From: Claire Booth
Sent: 28 January 2013 10:59
To: Jane Tucker
Subject: Highways - 3/2013/0041 Parish Hall, Lowergate, Clitheroe

From: Bloomer, David [mailto:David.Bloomer@lancashire.gov.uk]
Sent: 28 January 2013 10:25
To: Claire Booth
Subject: app 3/2013/0041 Parish Hall, Lowergate, Clitheroe

Proposed Plans (1:50)

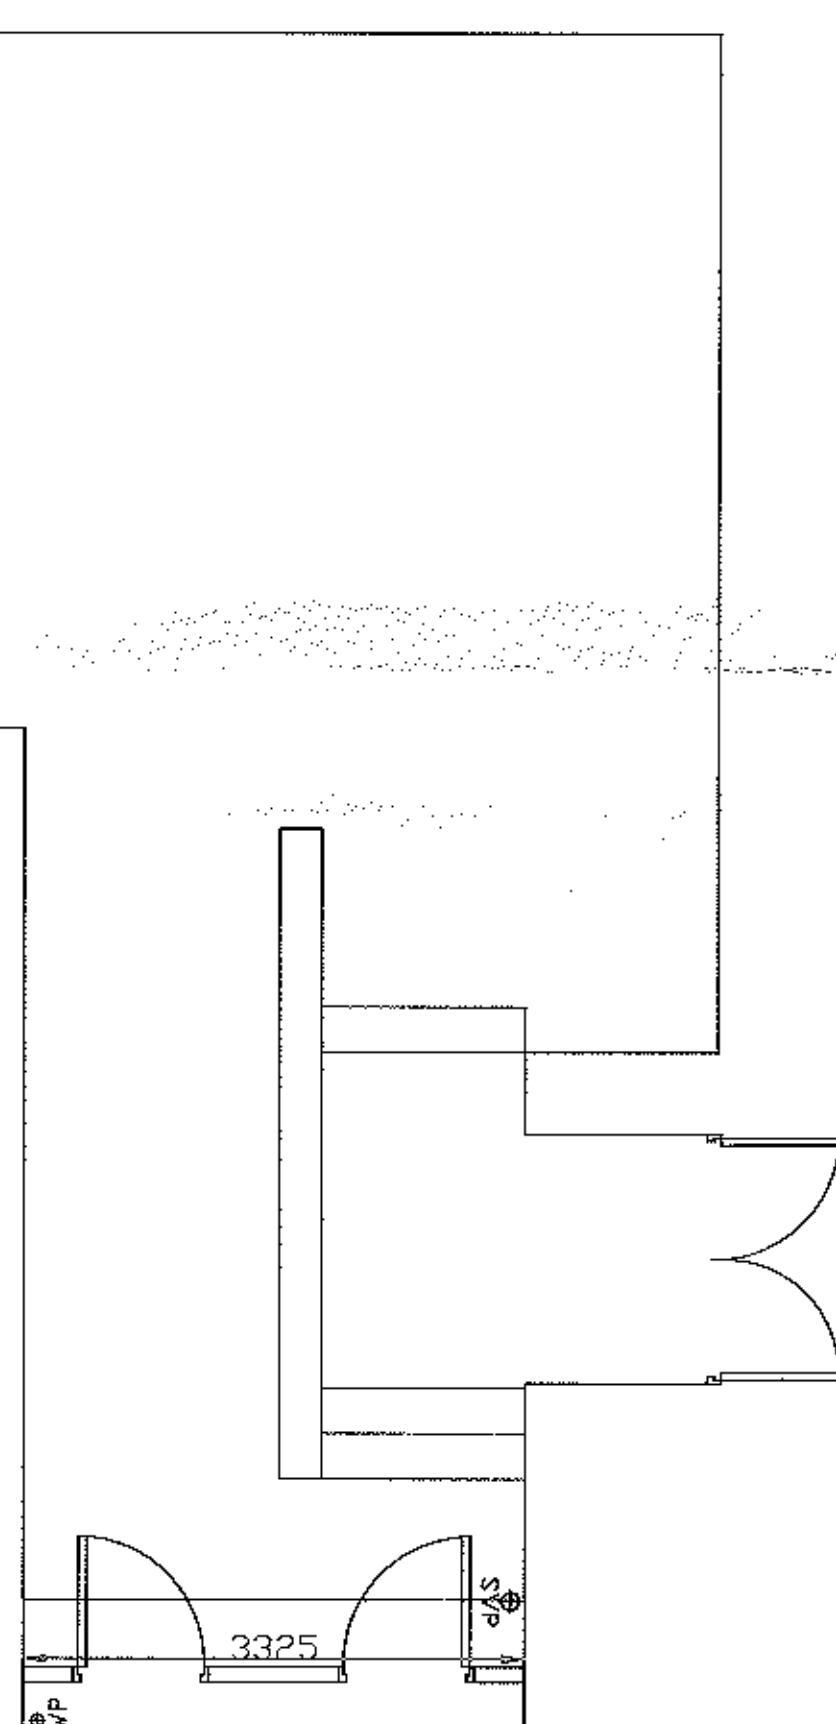
The above application has no highway implications and the submitted plan shows the pedestrian gates opening inwards into the site, I would therefore raise no objection to the proposal on highway grounds.
